Notice of Modification

Section 4.55(1) of the *Environmental Planning and Assessment Act 1979*

The Development Consent for the Jemalong Solar Farm (SSD 8803) granted by the Executive Director, Resource Assessment and Business Systems, as delegate of the Minister for Planning, on 18 May 2018.

Figure 1: Approved project site subdivision compared to proposed project site subdivision

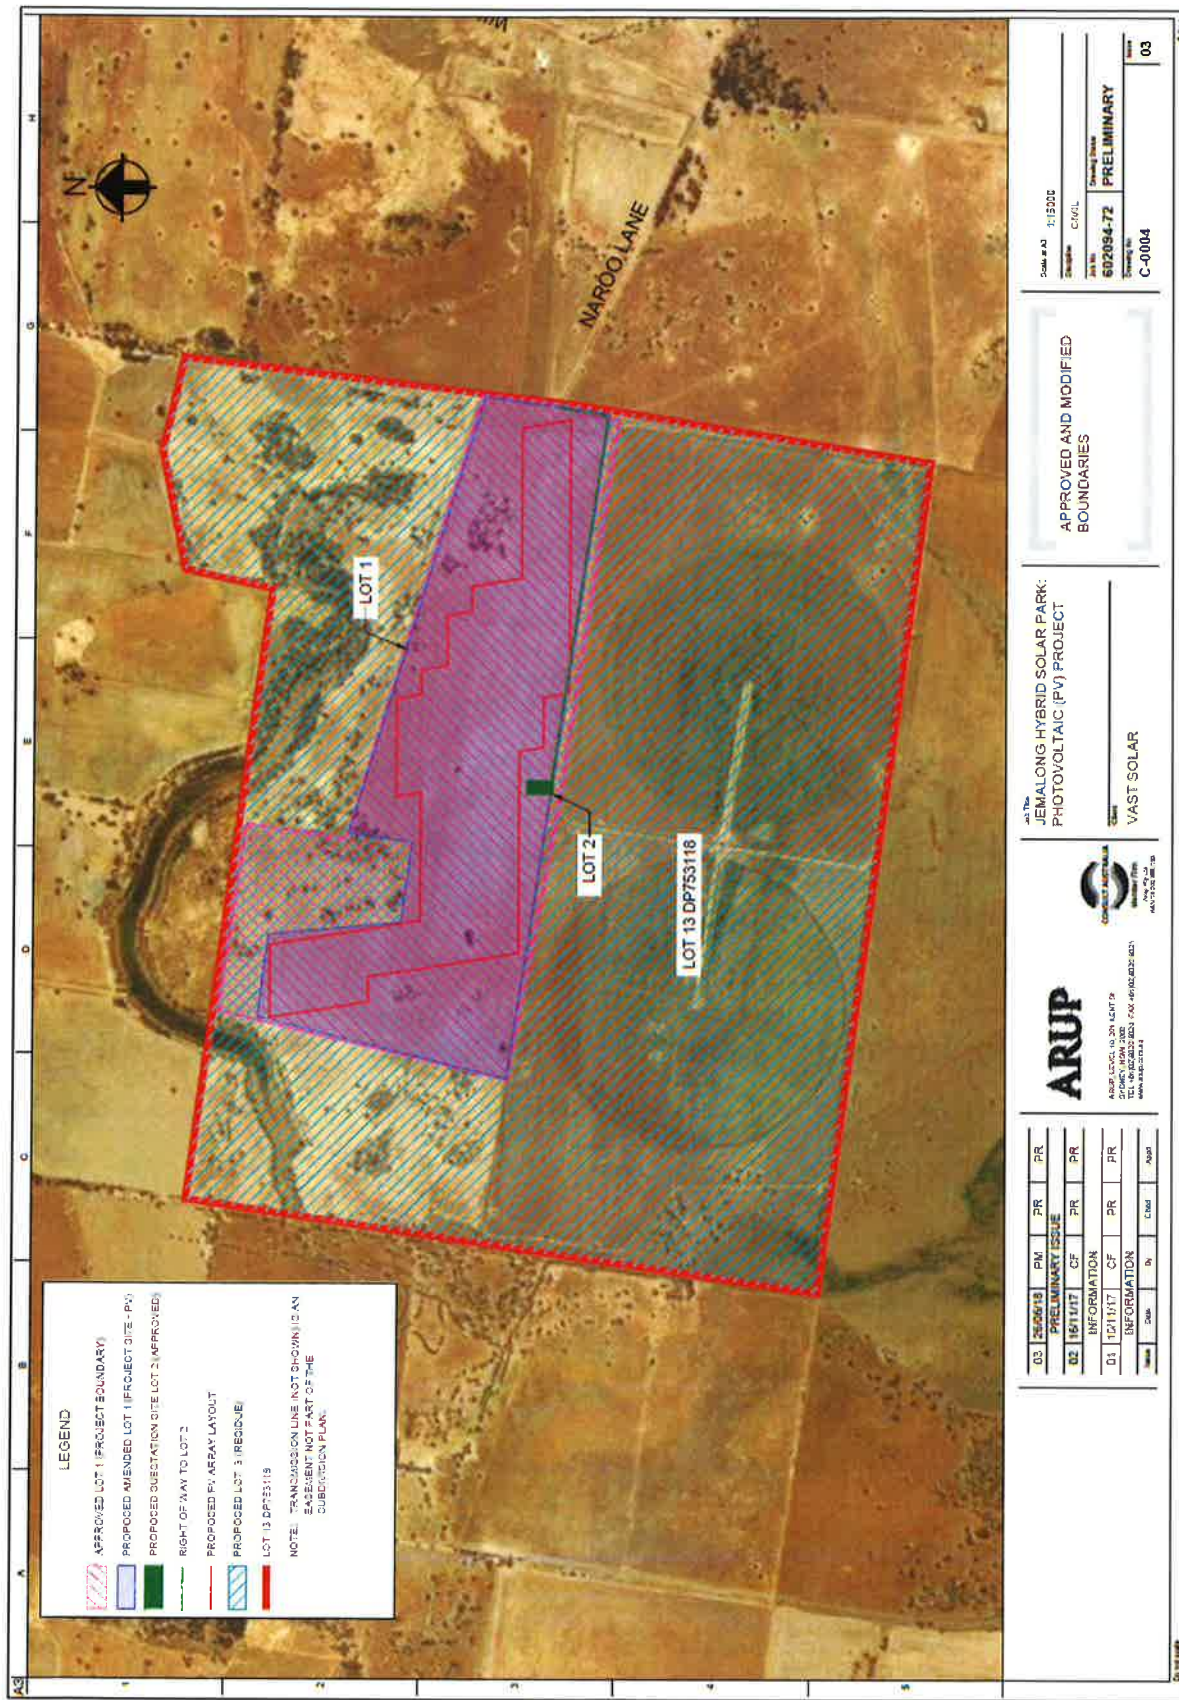
3. Delete the figure in Appendix 1 and insert the following:

13. The Applicant may subdivide Lot 13 DP753116 to create two additional allotments, in accordance with the EIS and the requirements of the EP&A Act and EP&A Regulation.
